Planning Application No: 3/2024/0721

Proposal: Proposed dormer to front and rear roofslopes and widening of the existing driveway entrance.

Location: Four Winds Whitehall Lane Grindleton BB7 4RL

PROPOSED SITE PLAN
SCALE 1,200 A2

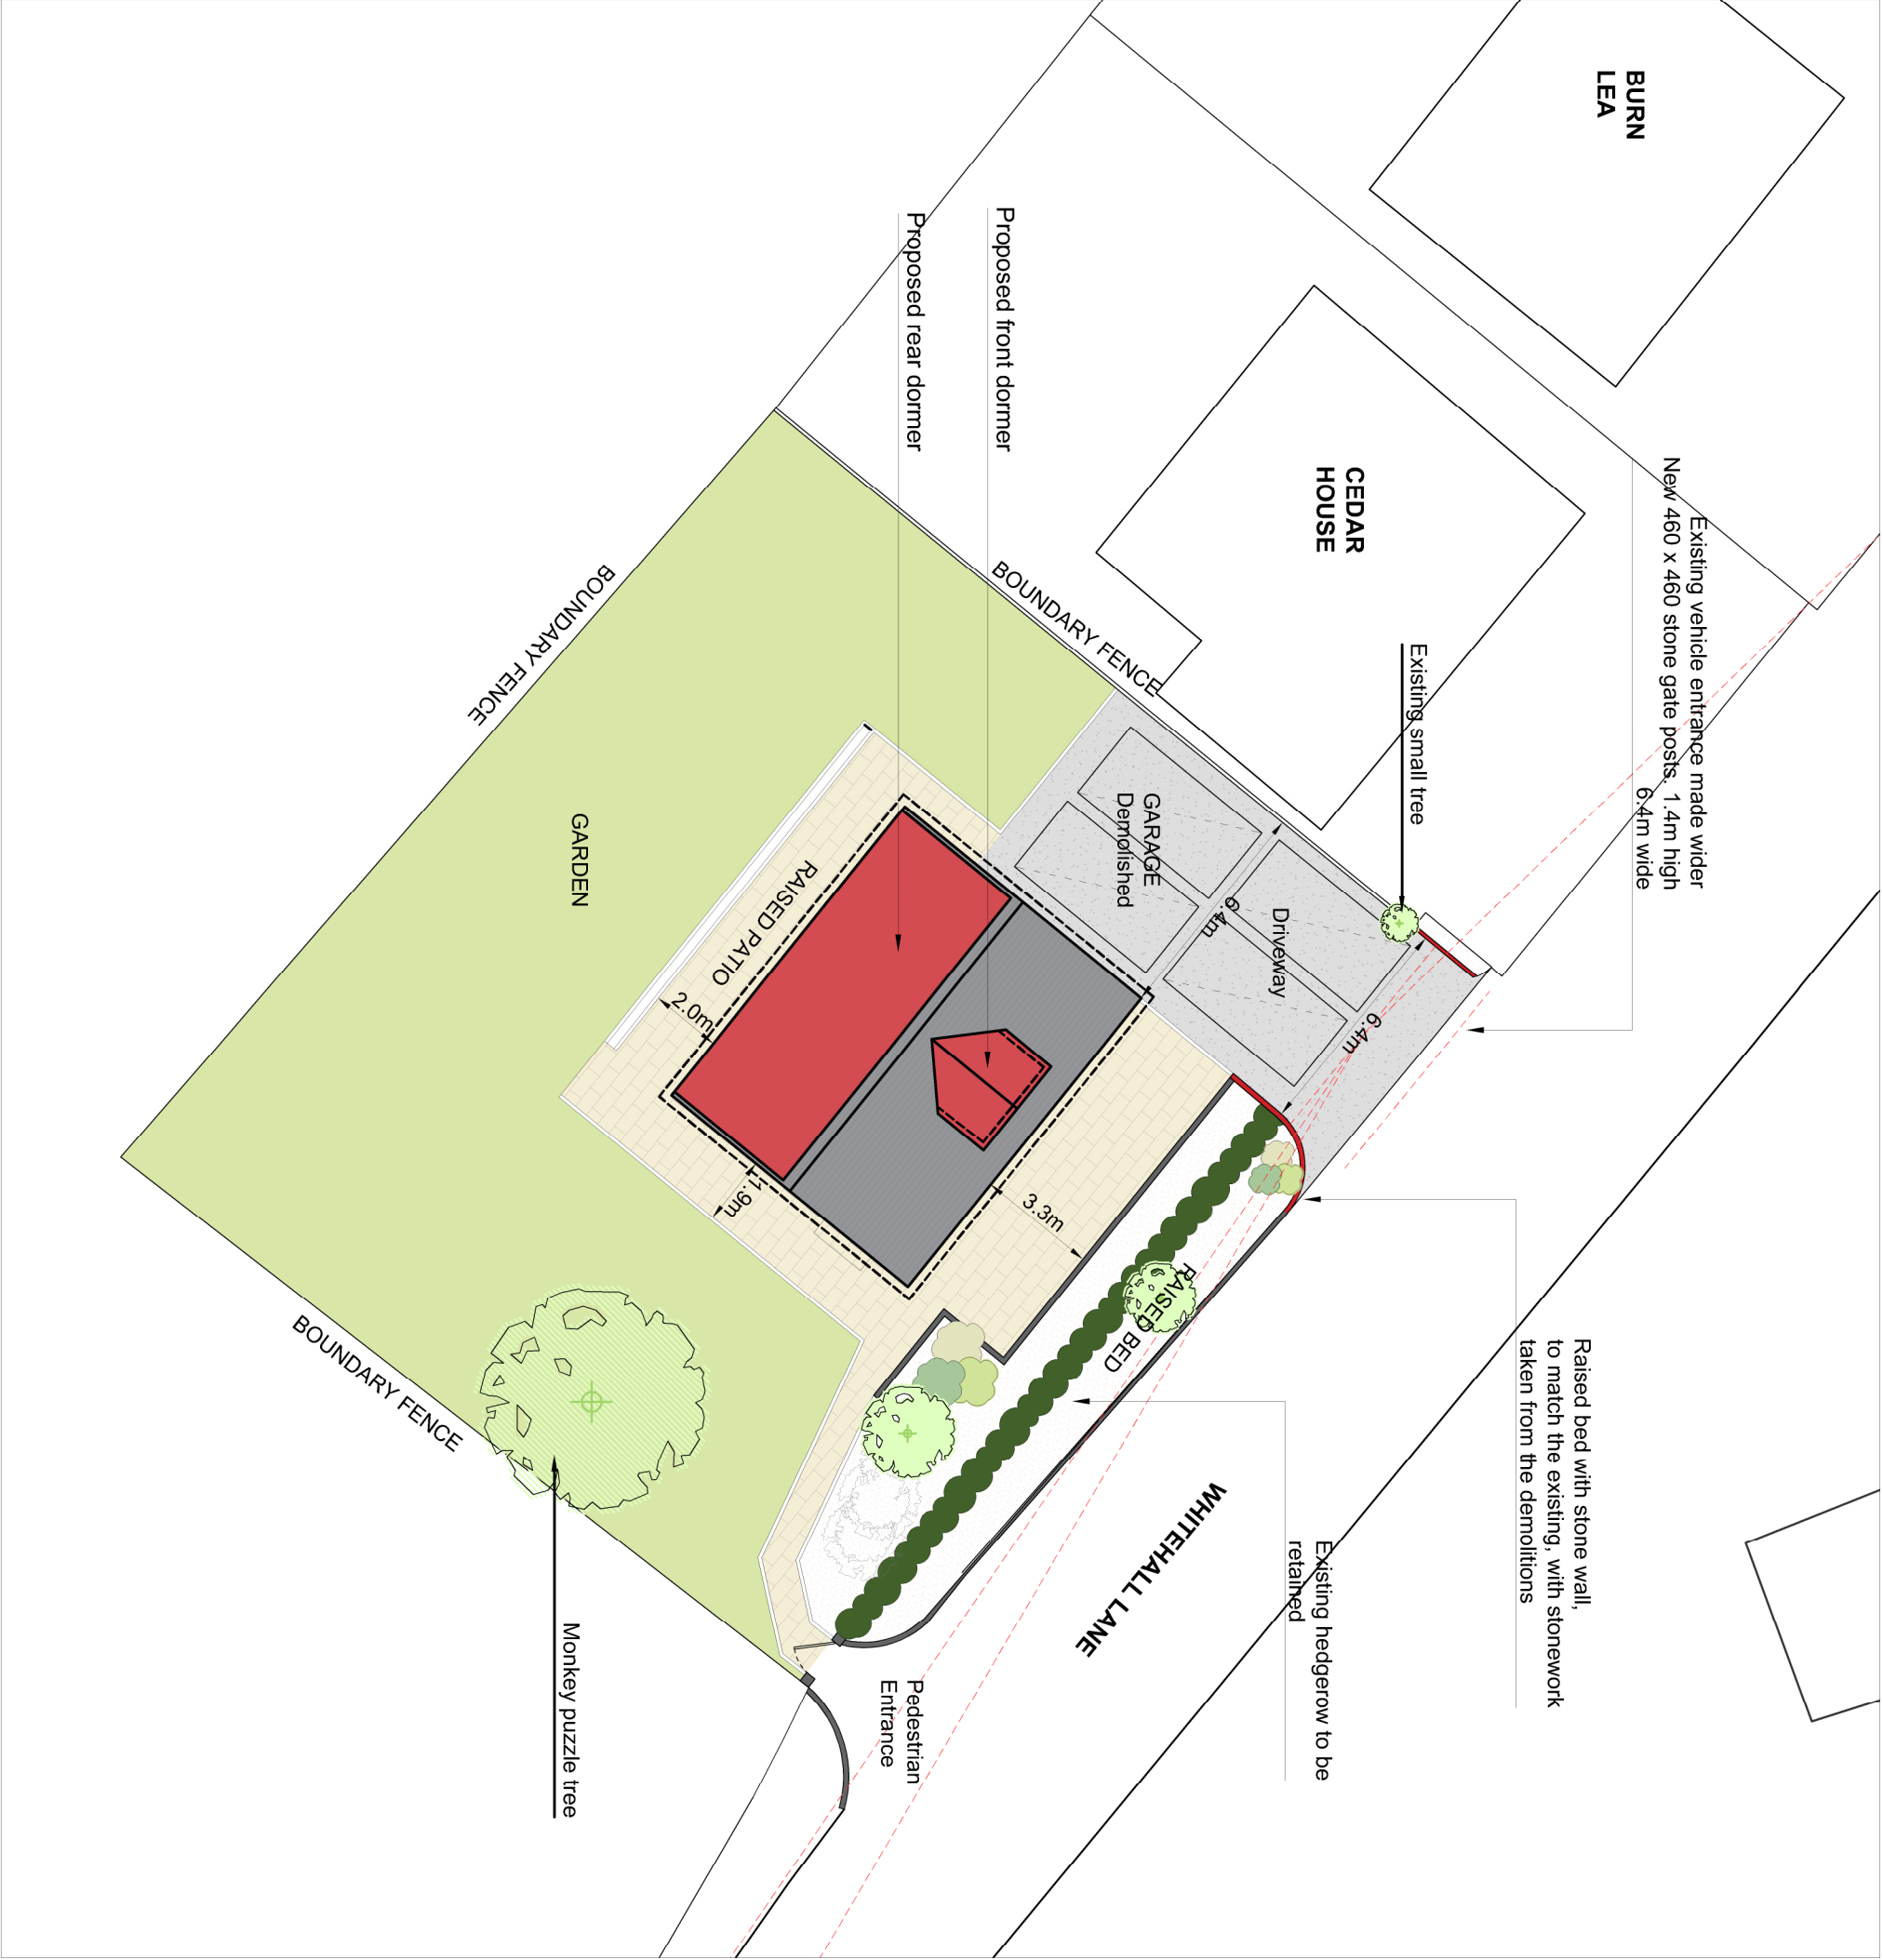
BW0321050 should not be obstructed during construction works.

- The parking areas must be constructed of a bound porous material and created before first occupation up until the lifetime of the dwelling existing in its proposed state. Reason: To ensure that satisfactory parking is provided before the dwelling hereby permitted becomes operative.
